DAVID EVANS
AND ASSOCIATES INC.

SUBJECT: Ogden Point Short Plat: Comment Response Letter

Thank you for your review of the Ogden point Short Plat. This letter is in response to your revised corrections letter dated August 22, 2019. We have prepared revised documents and included a revised short plat map, site plan, and tree calculations. Staff review comments are listed below in black text, the revised review comment in **red text** and our response to staff comments are provided in **Bold Italics**.

OGDEN POINT SHORT PLAT
 SITE PLAN
 THE LADYBUG TRUST
OGDEN POINT SHORT PLAT
 WASHINGTON
 CITY OF MERCER ISLAND,

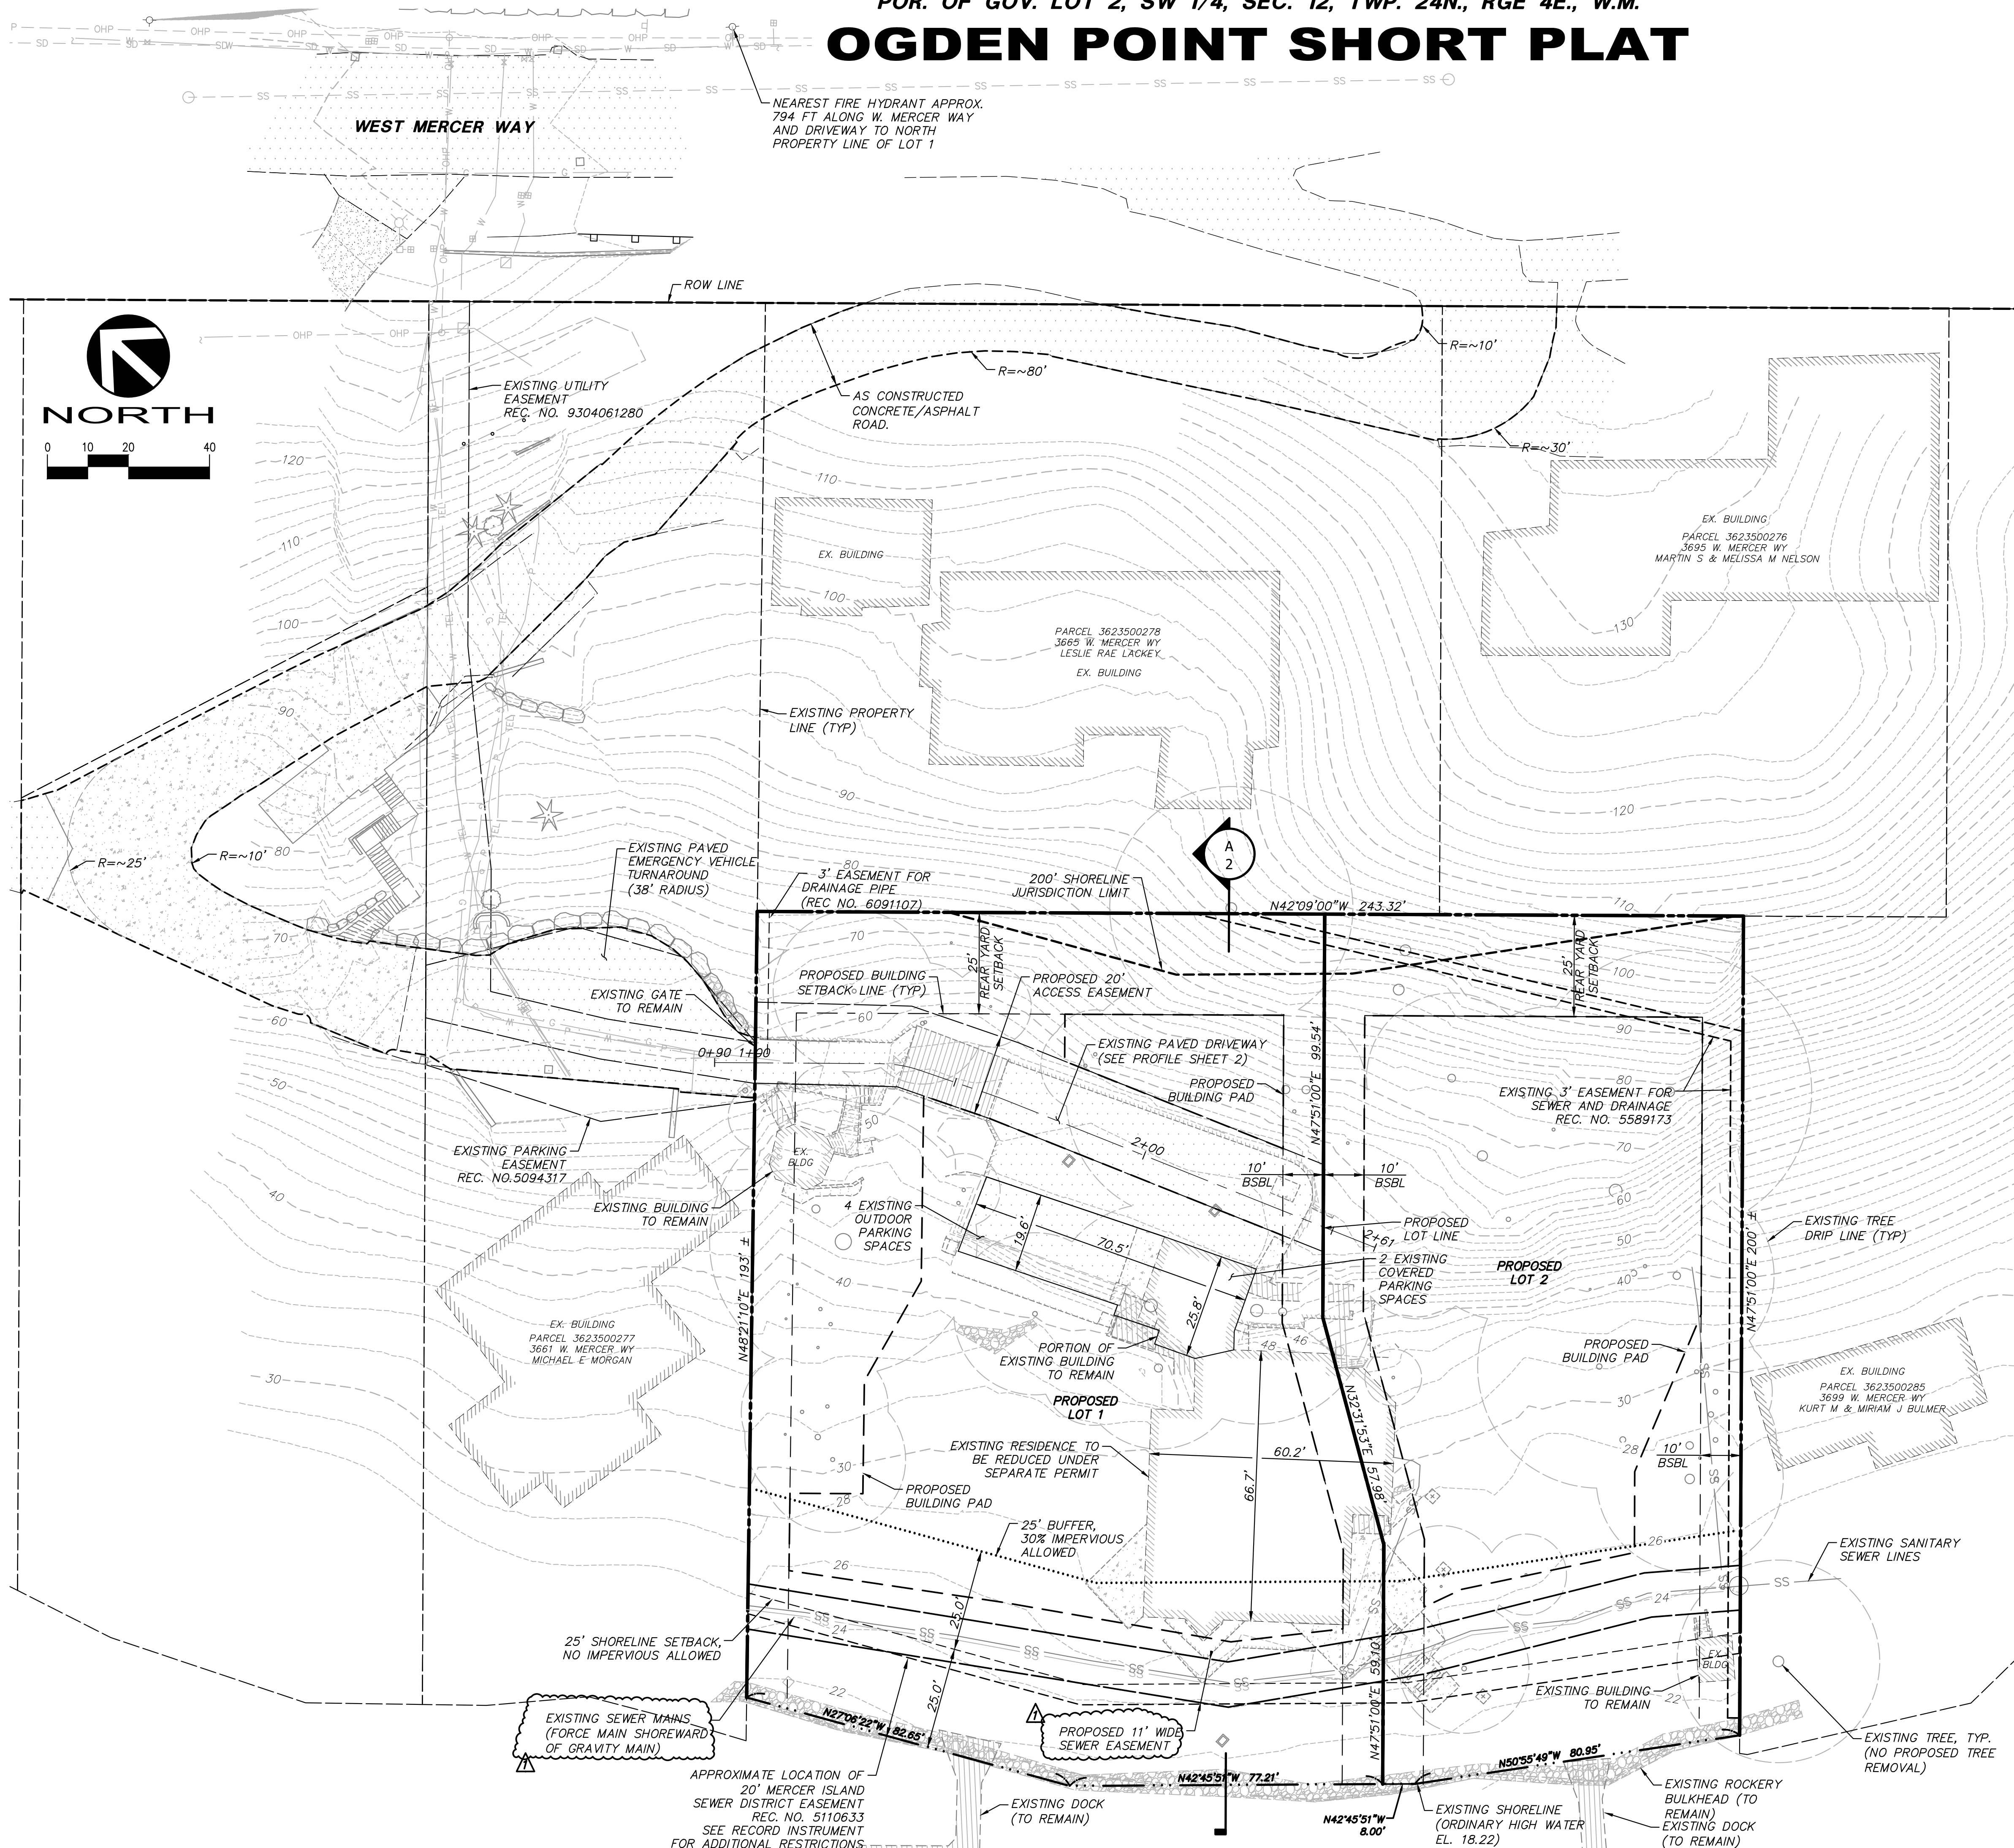
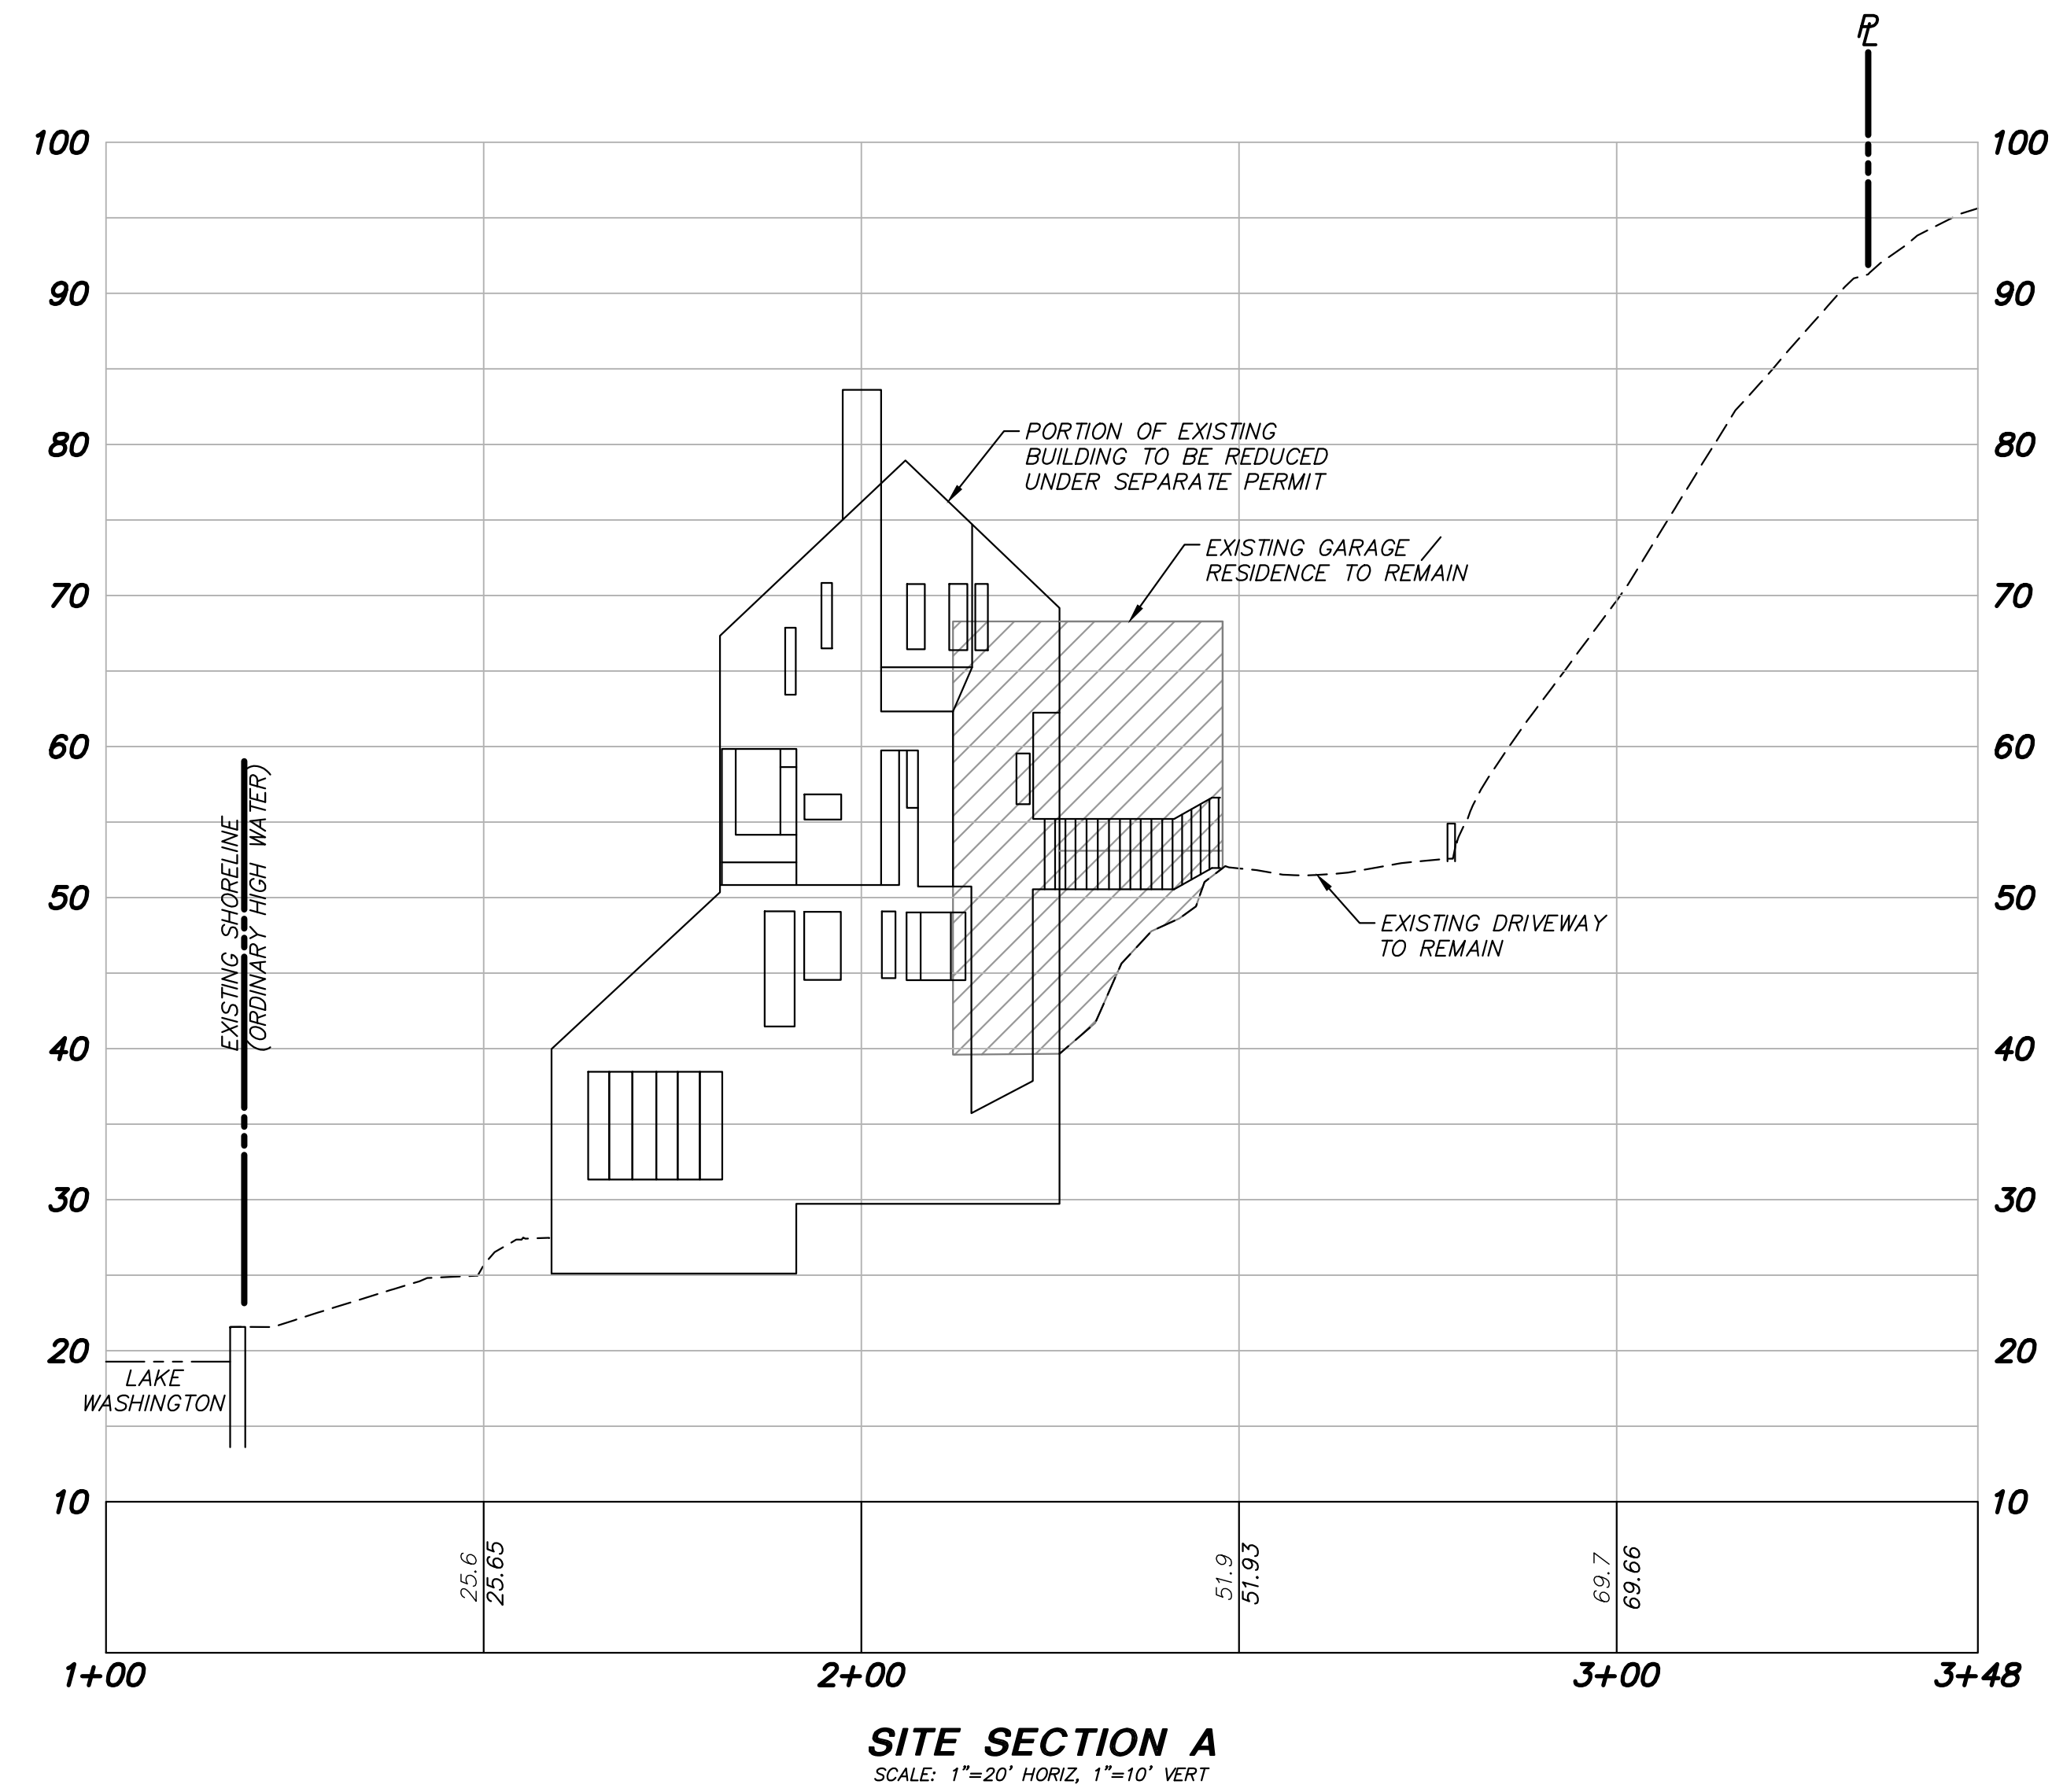
29. Please show the exact locations of the sewer gravity line and the sewer pressure line (it has been field located), then show a revised public sewer easement, 5 feet from the southern sewer line and 5 feet from the northern sewer line. Once the limits of the easement are reviewed, then you will need to provide the legal description for the sewer easement, and the City will provide the easement languages.

The sewer line was potholed and surveyed at the pothole location to verify the location and orientation of the two sewer lines. The additional locate work has confirmed the location of the sewer main shown on the Terrane survey. The Terrane Survey shows the location of the gravity main, while the pressure main follows the same alignment but is offset by one foot to the west (shoreward). These lines are shown on the short plat site plan.
